EN020026 : Sea Link

ACTEA Submission at Deadline 4

Further to ISH2 Agenda item 13.2 Construction Traffic and Indivisible Loads Suitability of routes proposed

Interested Party: Aldringham-cum-Thorpe Energy Action (ACTEA)

Suffolk Onshore Scheme Abnormal Load Routing Plan

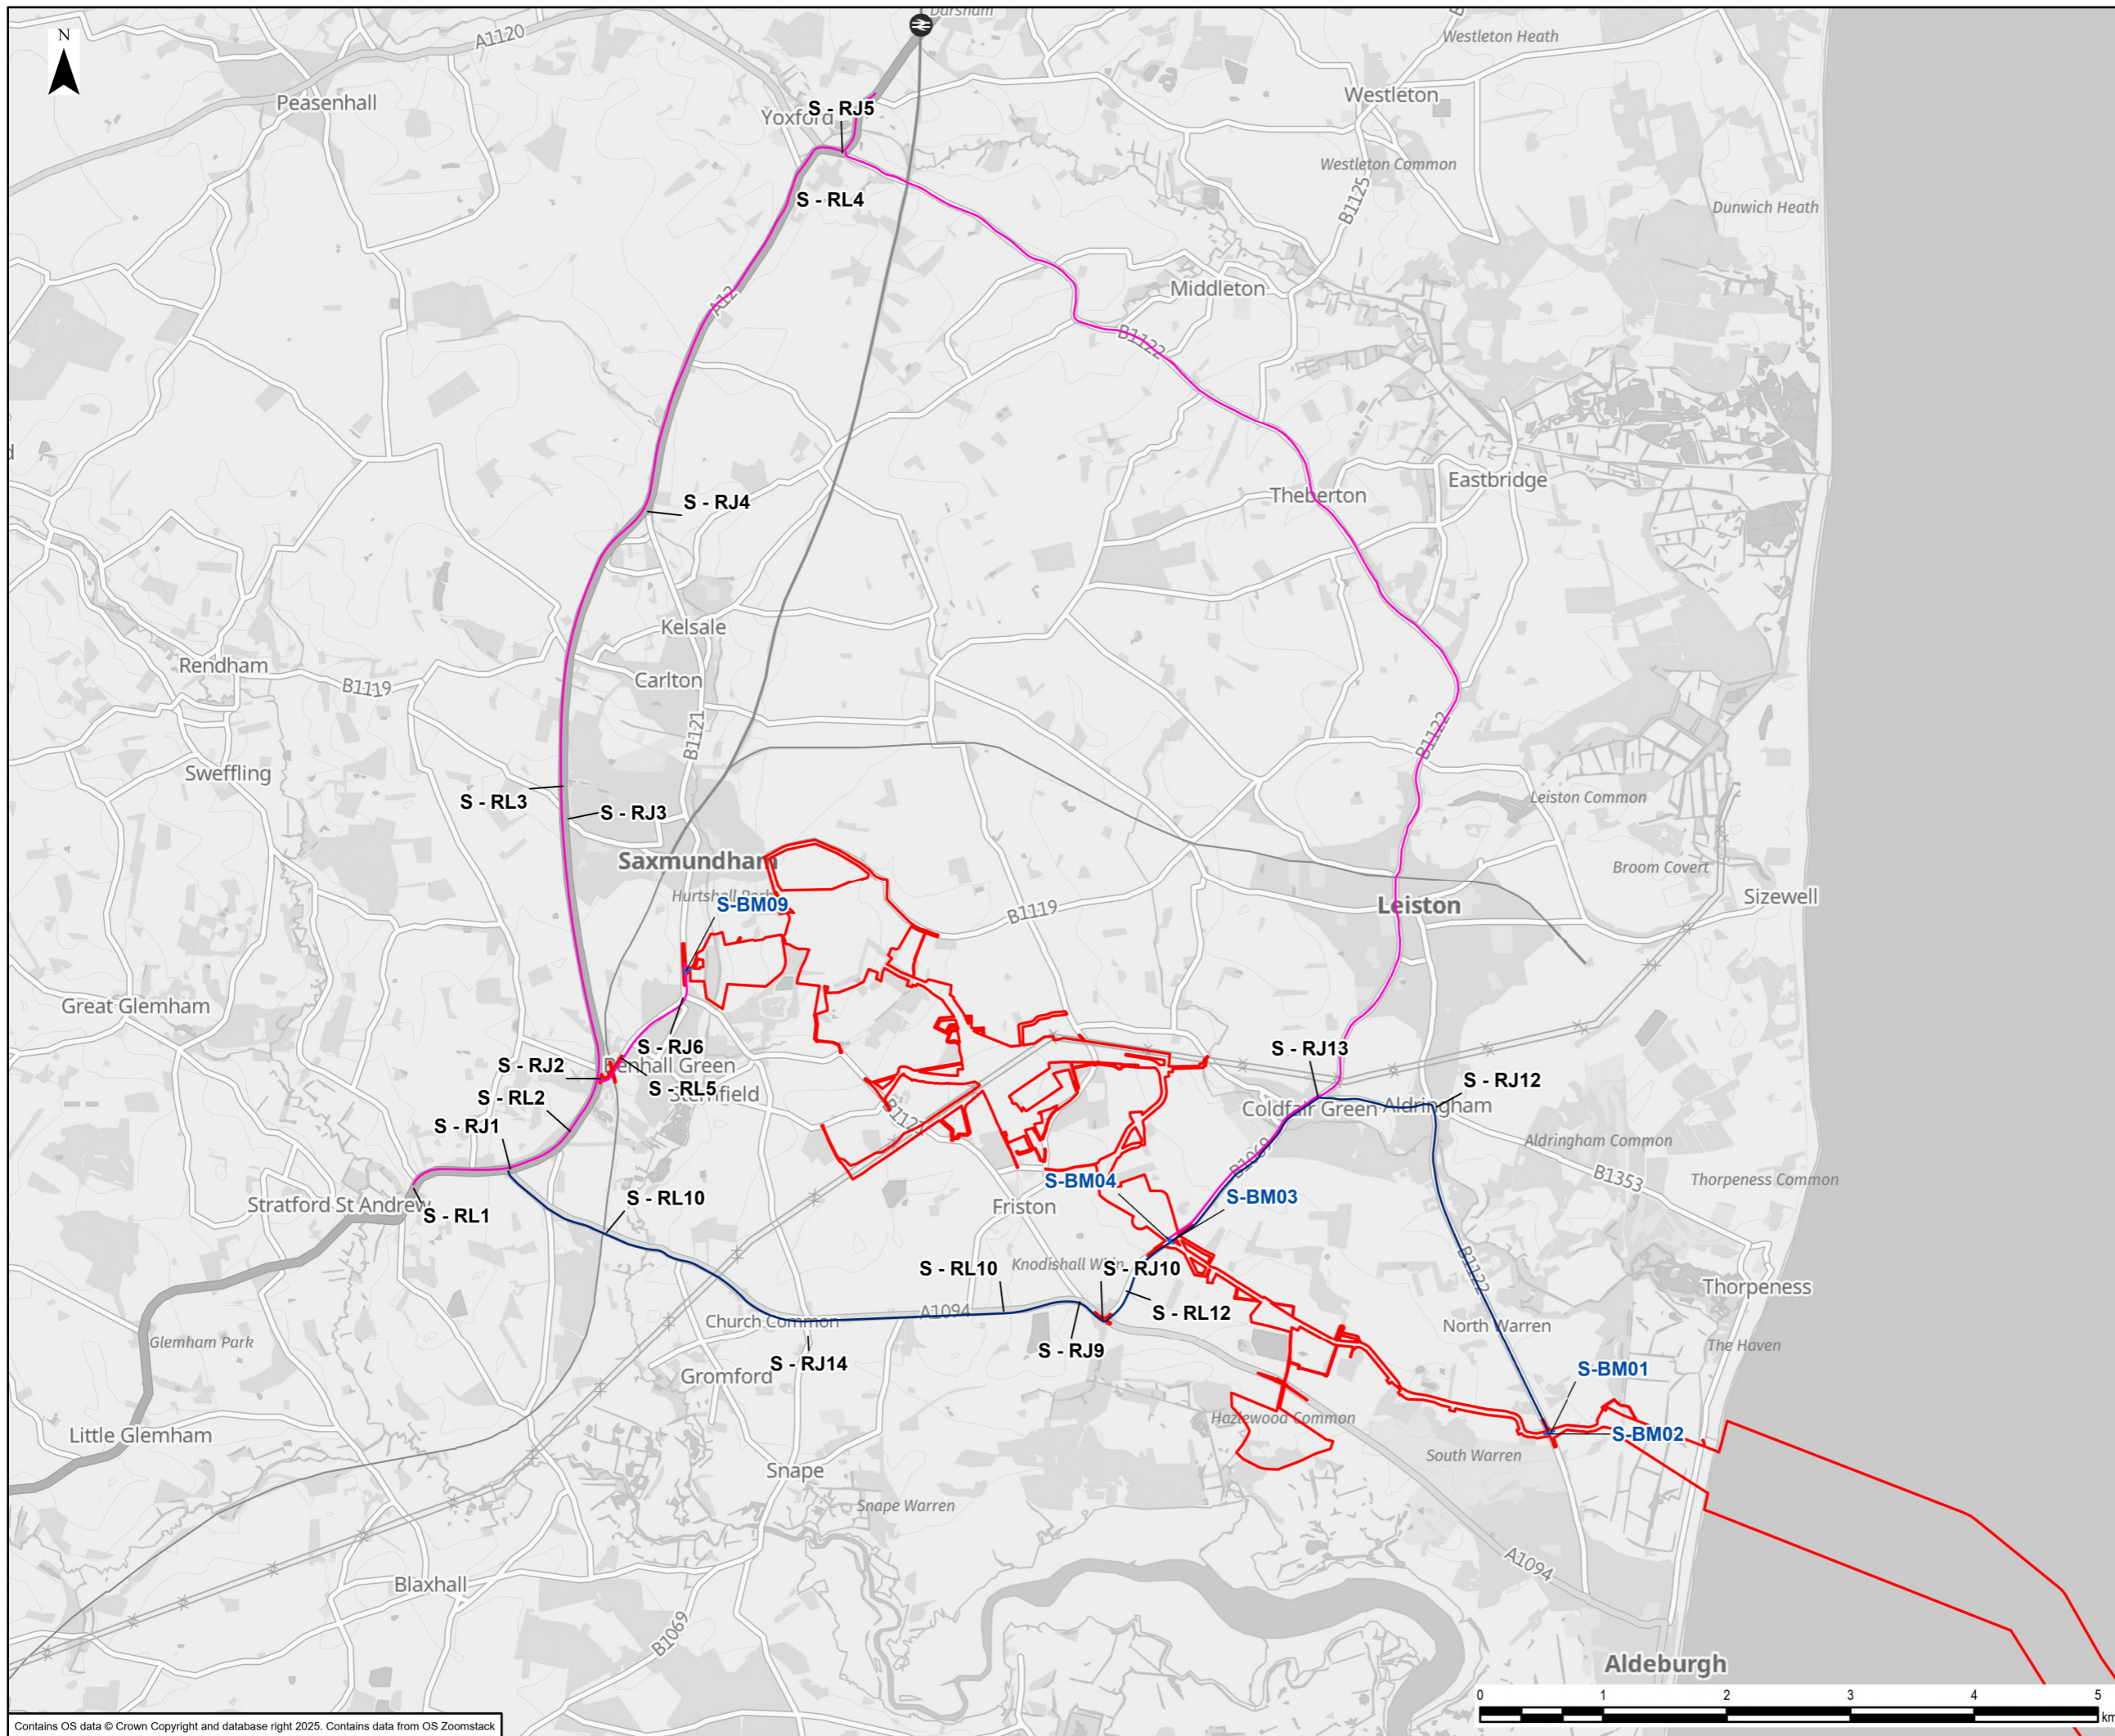
The Applicant's 'Thematic' response to concerns over the use of B1353 for construction traffic, as set out in *Table 7.10.8 'Applicant's Response to the Relevant Representations that raise Traffic and Transport'* on page 24, states that 'No construction vehicles are expected to travel along the B1353 as a result of the Proposed Project'. That response would seem to be contrary to what the Applicant has stated in:

[APP-234](#) *Application Document Traffic and Transport – Figures, 6.4.2.7.3 Abnormal Load Routing Plan - Suffolk Onshore Scheme* - indicates that the Applicant intends to route Cable Drum Abnormal Loads via B1353 Aldringham Lane between junctions B1069 junction with B1353 (S-RJ13) at Knodishall and B1122 junction (S-RJ12) at Aldringham.

[AS-008](#) and [CR1-041](#) *National Grid Electricity Transmission 7.5.1.1 (B) Construction Traffic Management and Travel Plan Suffolk – '6.1.8 Cable drum AIL access routes: Routes marked as Cable Drum AIL Access Only indicate those routes to be used by the cable drum delivery vehicle and that 'smaller' construction vehicles would also be expected to use the Cable Drum AIL access routes.*

Relevant Representations submitted by Aldringham-cum-Thorpe Parish Council and a Written Representation submitted by ACTEA at Deadline 1 suggested that the Applicant had not provided sufficient evidence to support the feasibility of and design for its planned routing along B1353 Aldringham Lane of Cable Drum carrier AIL vehicles and a number of 'Smaller construction vehicles' that would also be expected to use Cable Drum AIL access routes.'

The Applicant states that it had relied upon National Highways' website portal ESDAC software tool (Electronic Service Delivery for Abnormal Loads) to identify constraints to access for AILs. According to ESDAC, Junction AC11 Aldringham Lane/Aldeburgh Road movements would be constrained by tight geometry that may necessitate junction widening,

and removal of traffic islands, street furniture, including street lighting and signposts.

The Parish Council and ACTEA also mentioned that Scottish Power Renewables (SPR) had previously carried out its own survey of Aldringham Lane in 2018 and had concluded that 'The B1353 (Aldringham Lane) between Aldringham and Coldfair Green is not wide enough for two HGVs to pass one another and that widening at this location would not be possible due to the proximity of residential properties to the edge of the road'. Consequently, SPR decided that HGVs would not travel between Aldringham and Coldfair Green.

The Applicant states that 'it is expected that the contractor will review all access constraints in more detail at a later stage, carry out any additional assessments where necessary and that alternative routes will also be used if necessary'. Given the possibility that there may not be a workable alternative route for the Cable Carriers needed for cable laying at Aldeburgh, we respectfully suggest that even at this stage of the Examination ExA makes sure that the Applicant has presented an acceptable design for this section of the Cable Drum Carrier ALO route, including swept path turning designs and all temporary and/or permanent modifications and alterations that would be needed along Aldringham Lane and at its junctions with B1069 and B1122.

It should be stipulated in Outline Construction Traffic Management and Travel Plan – Suffolk that B1353 Aldringham Lane may be used by Cable Drum Carriers only if a design for this section of the proposed ALO route is acceptable to the relevant Local Authority and, in view of its narrow width, that other construction vehicles should not be permitted to use it.
